Please ask for: Sian Eggington
Email: sian.eggington@terraquest.co.uk
Telephone: 0121 2341390
Our Ref: FP/152/20/HH
Your Ref:
Date: 21st August 2020

Application for Planning Permission for Works or Extension to a Dwelling

Development: Rear extension.
Location: 8 Burley Road Felpham PO22 7NF

Proposed Roof Plan

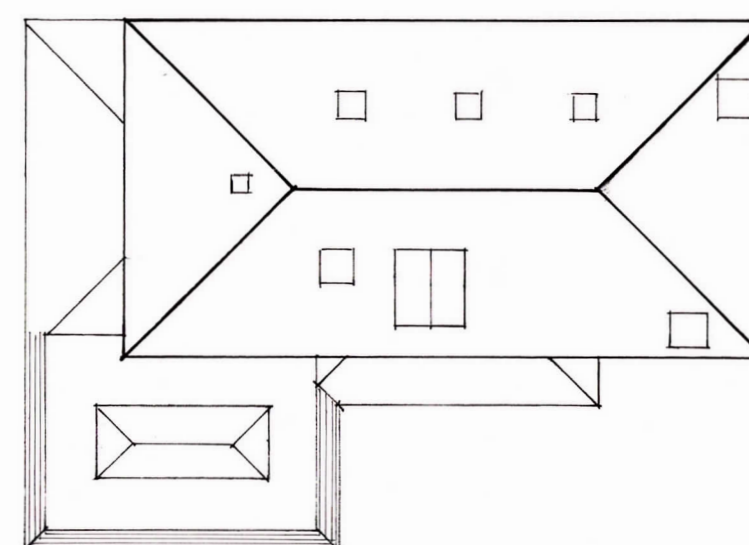
Dimensions: You are required to include dimensions on the proposed block plan from the extension to all site boundaries.
